## Department of Transportation

SH 24G  
El Paso County

- RE: Falcon Fire #3 PPR - Revised Comments
- For review the Letter of Intent dated 05/12/2016
  - For review the Site Development Plan dated 12/24/2019

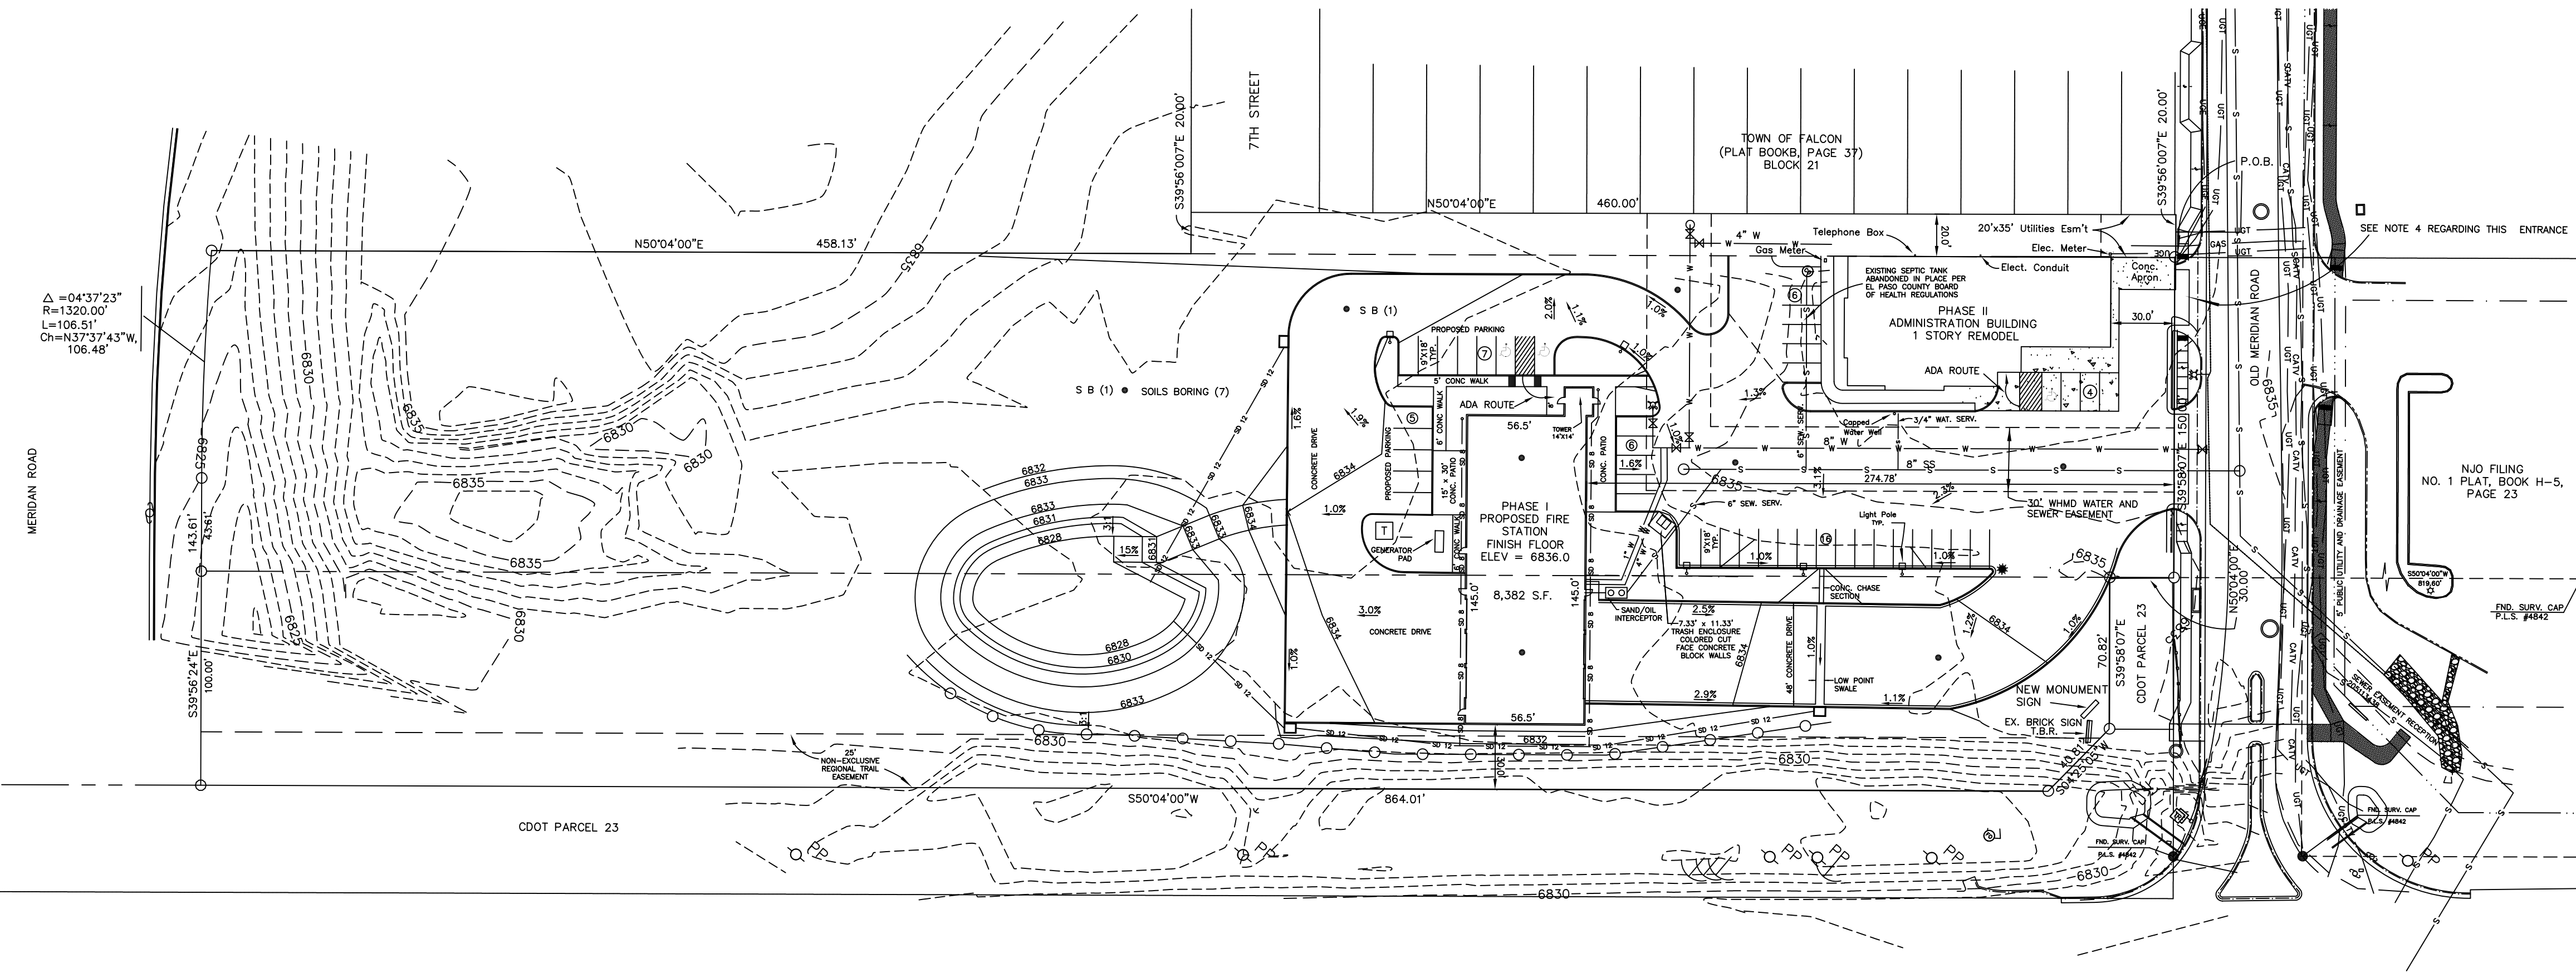
- 1) A State Highway Access permit will **not** be required at this time for the impacts to the intersection of SH24/Old Meridian Rd.
- 2) CDOT Access Department does not recommend the Access to the Fire Station parcel be at a distance so close to the intersection to potentially impare traffic operations to the SH24/Old Meridian Rd. intersection. However, I consulted with CDOT Traffic Operations Department and the CDOT Corridor Manager for SH24G and found that they have been in coordination with the development team. They have determined that they are ok with the Fire Station access to Old Meridian Rd. and how it interacts with SH24 with the implimentation of a right in/right out median island at the westside of the intersection of SH24. The median island will be designed in a way that is mountable by big trucks and not passenger vehicles along with the installation of a special traffic signal for the fire station use to egress onto Old Meridian Rd. in case of emergency.
